### **Rock Creek Canyon-Snell Parcel Acquisition, EX-18-002**

Please accept the following comment from El Paso County Public Health for the project referenced above:

CHEYENNE MOUNTAIN STATE PARK EXPANSION - ROCK CREEK CANYON PARCEL
EXEMPTION PLAT
CITY OF COLORADO SPRINGS

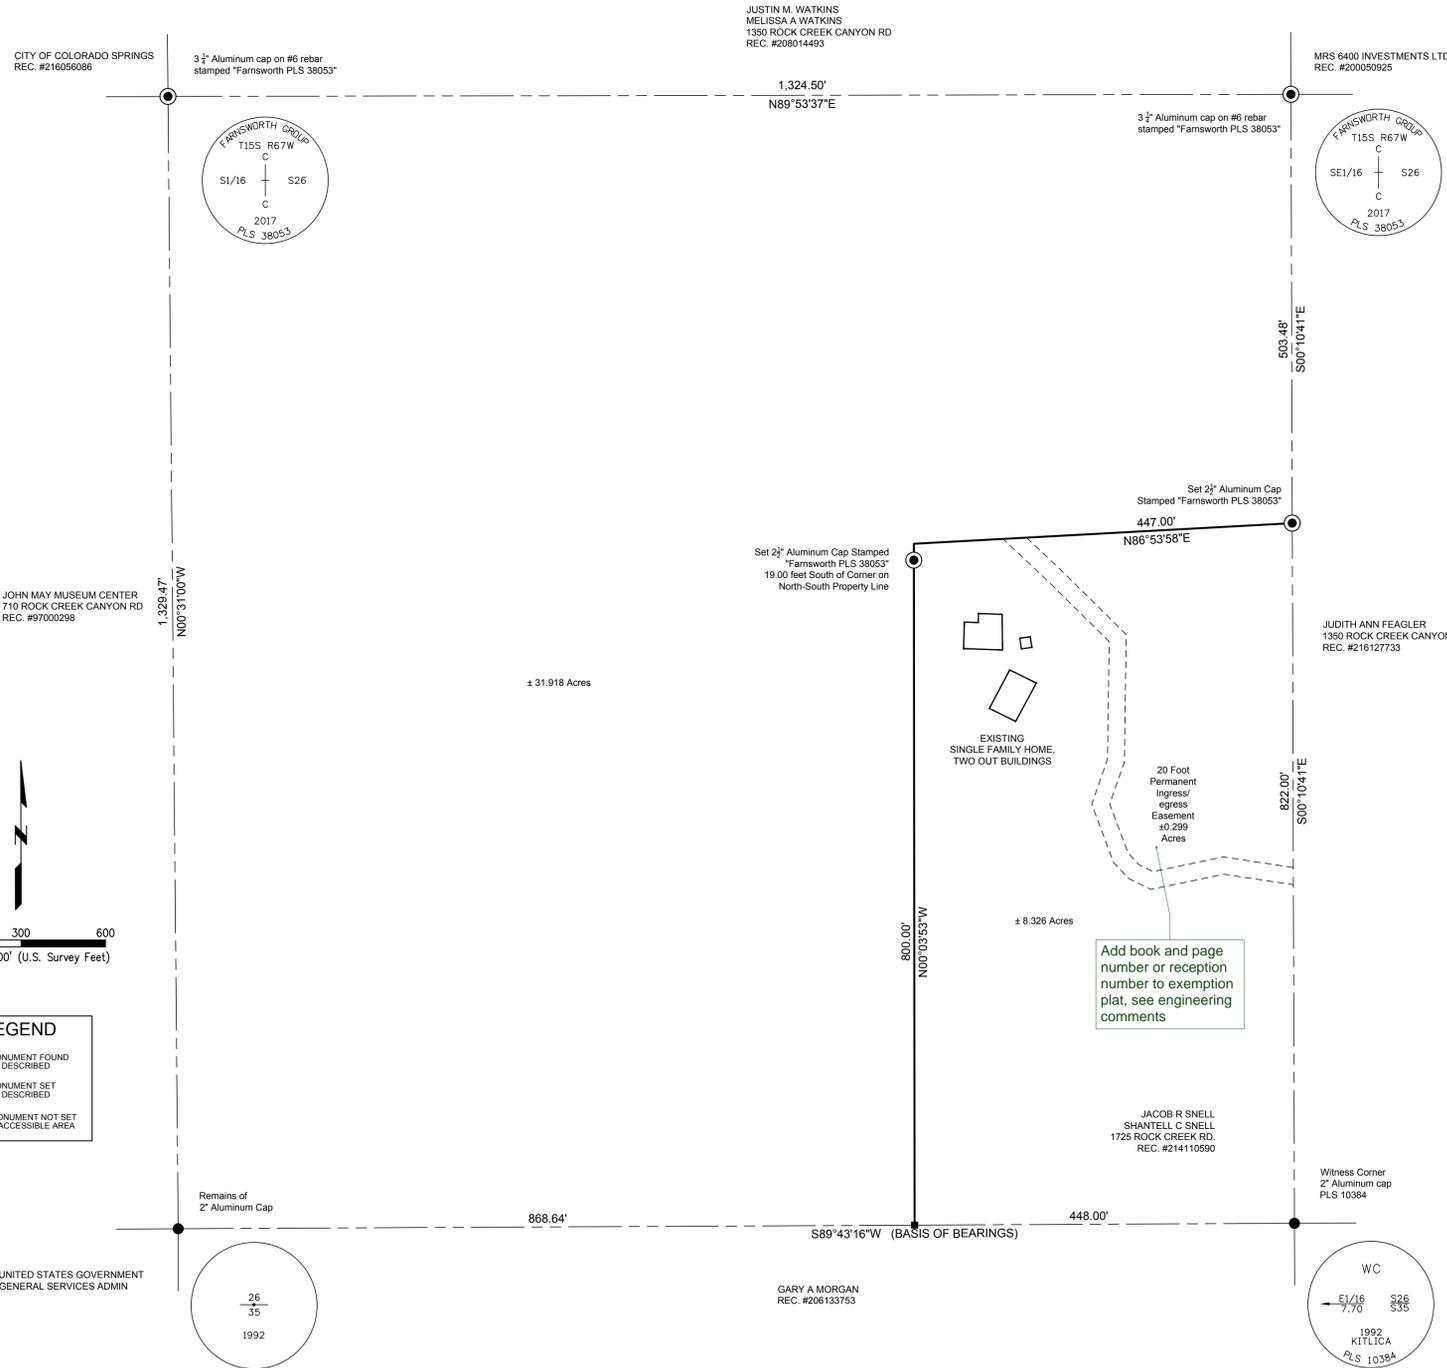
- **There is an existing onsite wastewater treatment system (OWTS) on the 8 acre parcel. Assurance must be made that all OWTS components and the well are entirely contained on the lot and meet the OWTS Regulations minimum installation setbacks.**
- **No other issues noted by El Paso County Public Health with the approval of this exemption request.**
